Appeal Decision

Appeal Ref: 6006768

38 Lees Road, Hillingdon, Uxbridge, Middlesex UB8 3AT

PROPOSED PLAN

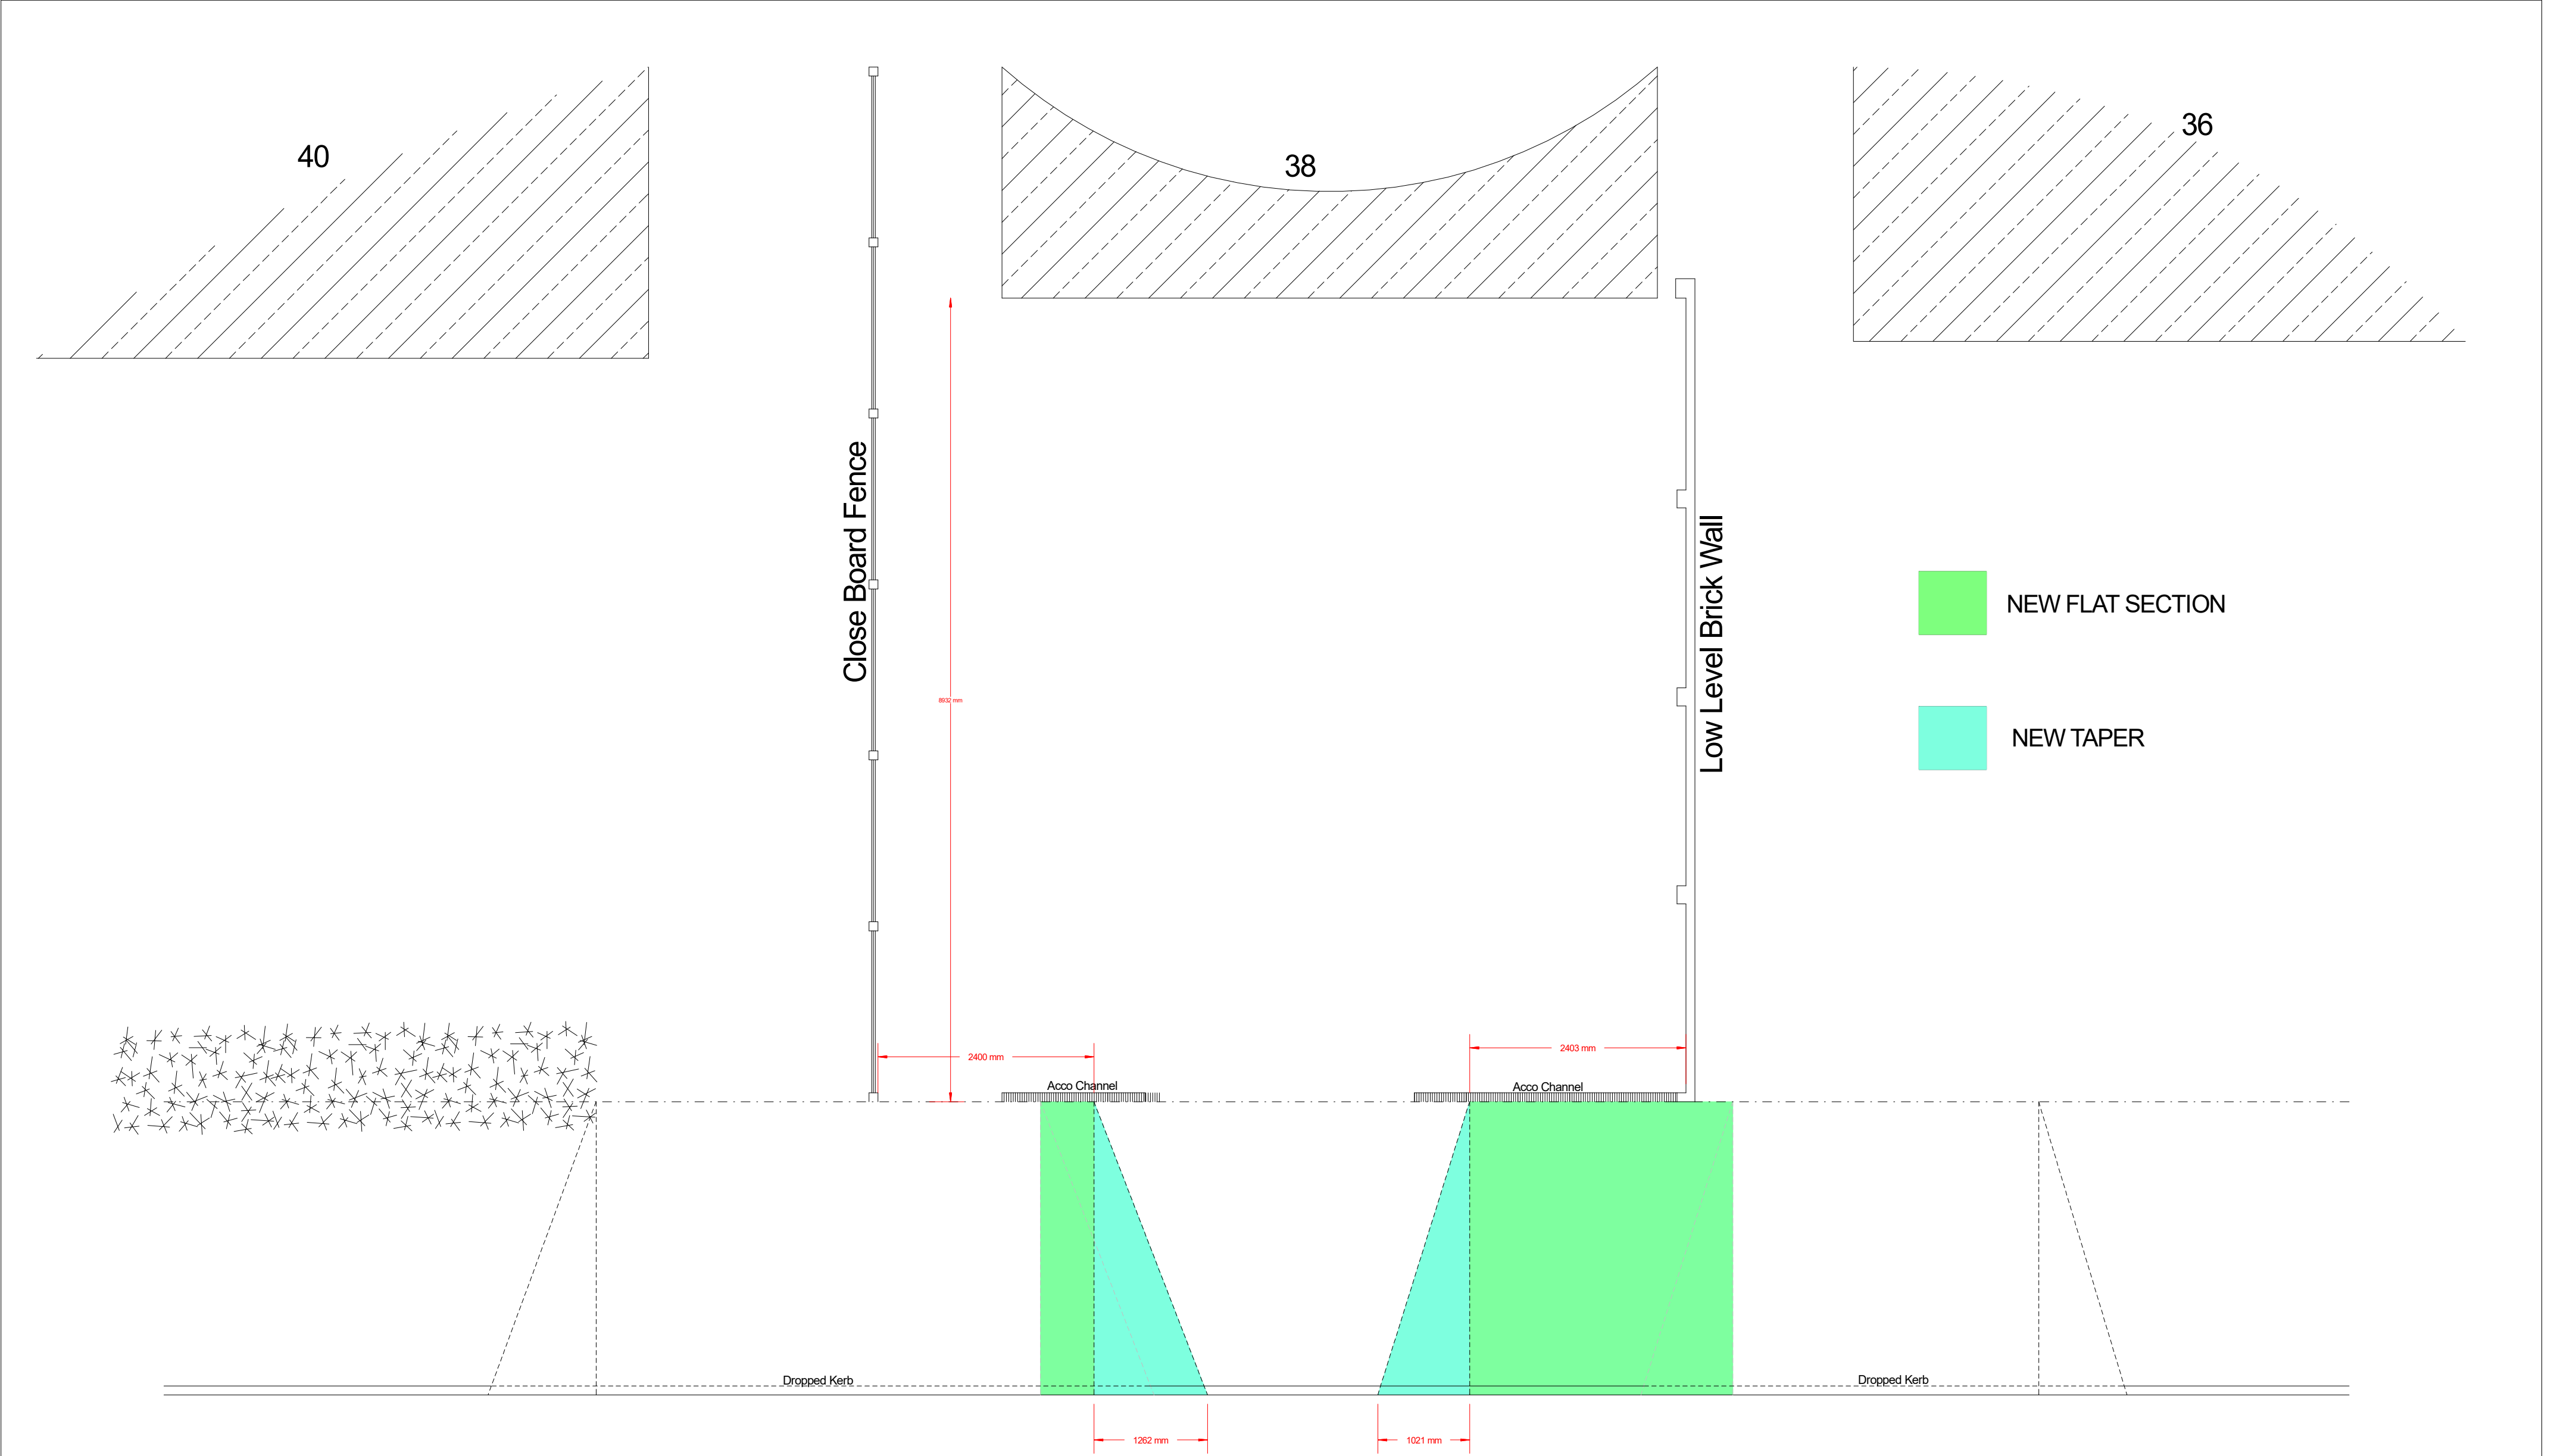
4. The proposed crossover would be located fairly centrally relative to the host's hard surfaced forecourt, and would not cover the whole of the plot frontage. Based on the submitted drawings, there would be a narrow flat section of pavement between the proposed crossover's tapered edge and the existing crossover which, following the erection of a boundary fence, now just serves No 40, and a wider flat section of pavement between it and the crossover which serves No 36.

5. The section of flat pavement between the scheme and No 40 would be narrow, but the section adjacent to the crossover at No 36 would provide sufficient space for pedestrians, some of whom may have pushchairs, to wait if necessary, to allow a vehicle to cross. That said, the amount of traffic serving a single dwelling would typically be very limited, and those instances would be infrequent.

6. Moreover, given the alignment of the highway and the absence of nearby street furniture, and having regard to the proposed crossover's set in from the plot's low side boundaries, pedestrians on the pavement would have a good view of vehicles accessing the site, and those drivers would have a good view of pedestrians. Thus, with appropriate care and attention by all highway users, instances where pedestrians would have to step onto the carriageway to avoid a vehicle accessing the site would be very infrequent.

8. For the above reasons, having regard to the context of this site, and assessed on its planning merits, I conclude that the scheme would not have a harmfully adverse impact on the safety and convenience of highway users.
